Appendix

Conservation Management Plan (CMP)

The bullet-pointed text below denotes advice and recommendations that Historic England gave regarding the CMP as part of our consultation response to the 2019 planning application. We have provided additional comments and recommendations below this initial advice; where it may be helpful and relevant.

The original of this drawing was produced in colour - a monochrome copy should not be relied upon

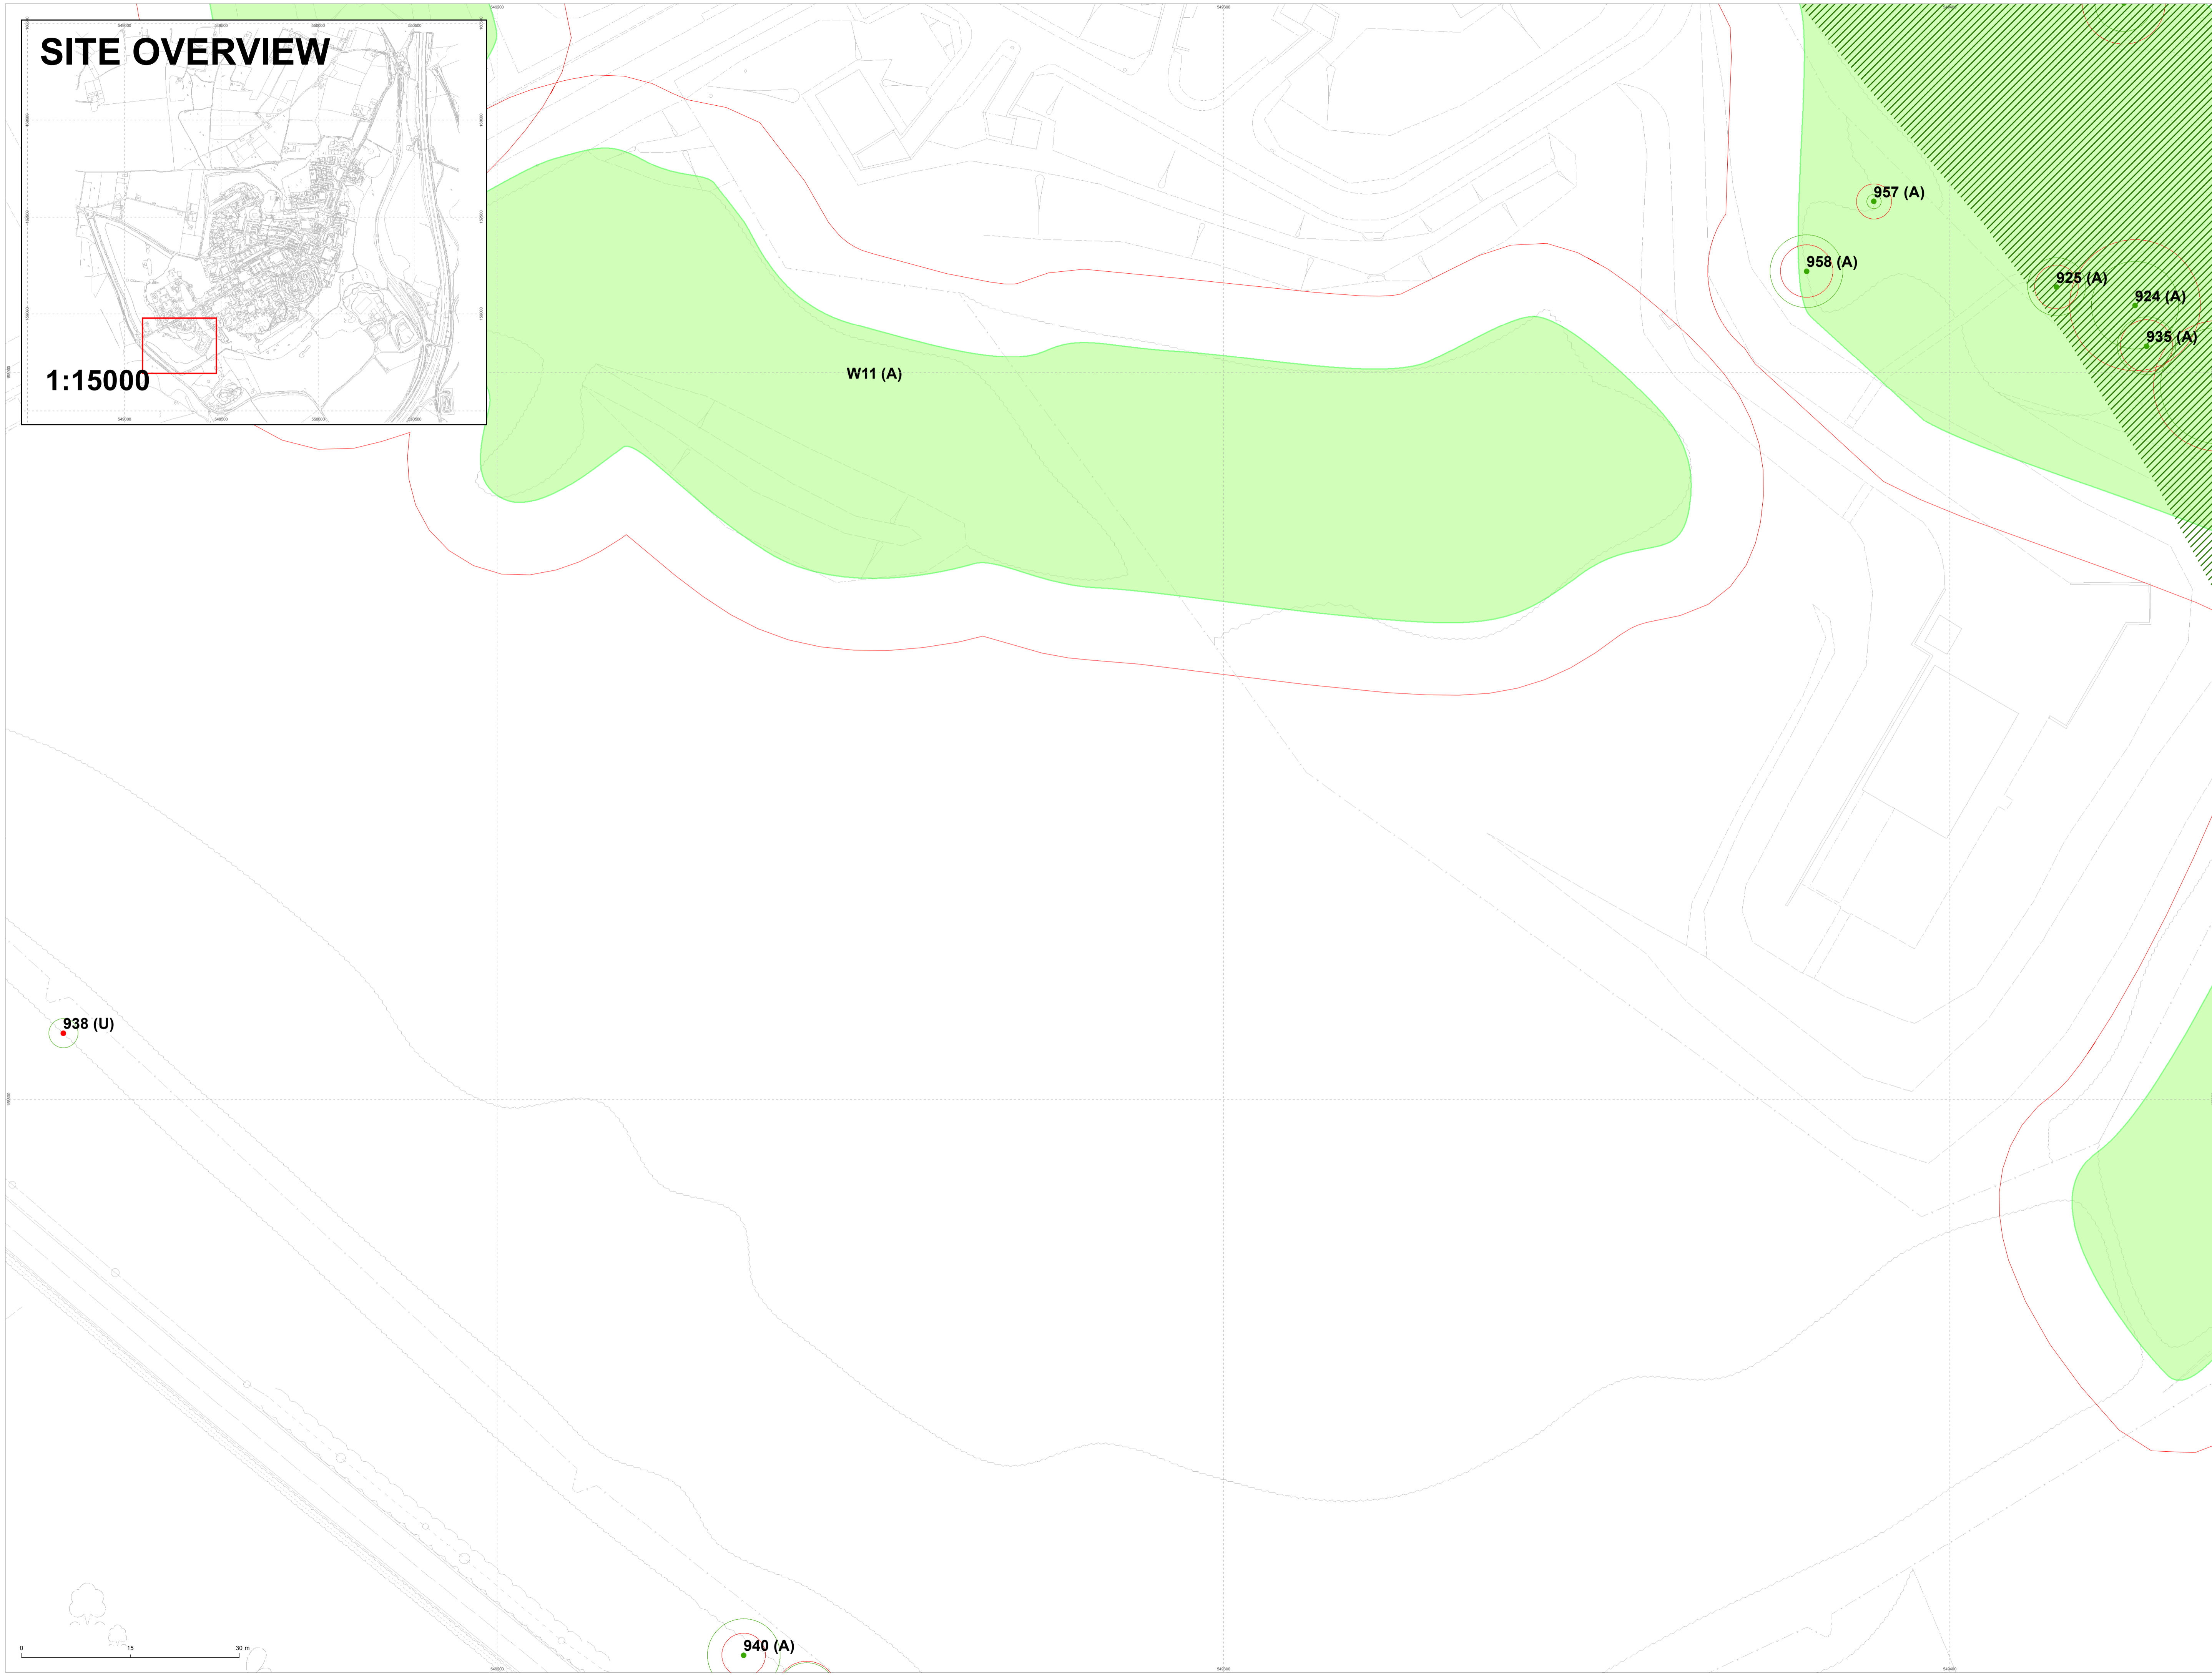
- 3) “More information should be provided regarding provision to reveal key views and aspects of the fort’s setting.”

We are pleased to see that the revised CMP includes acknowledgement of the need to reveal key views and aspects of the fort’s setting. However, currently the report

does not progress beyond an intention to provide for this, and includes no more detailed information on the specific aims or proposed methodologies for such. We recommend that further assessment and consideration should be given to:

- Which specific key views/aspects of setting should be revealed and thus which areas of vegetation/trees will require removal
 - Whether tree removal/retention will have any structural impact on the historic fort (as informed by an arboriculturalist)
 - Whether any ecological considerations will need to be taken into account (as informed by consultation with Natural England).
- 4) “Agreement of the details of the structure, governance and funding of a community trust or management company, which should demonstrate specific duties and protections with respect to the conservation of the fort and any other heritage assets for which it will be responsible.”
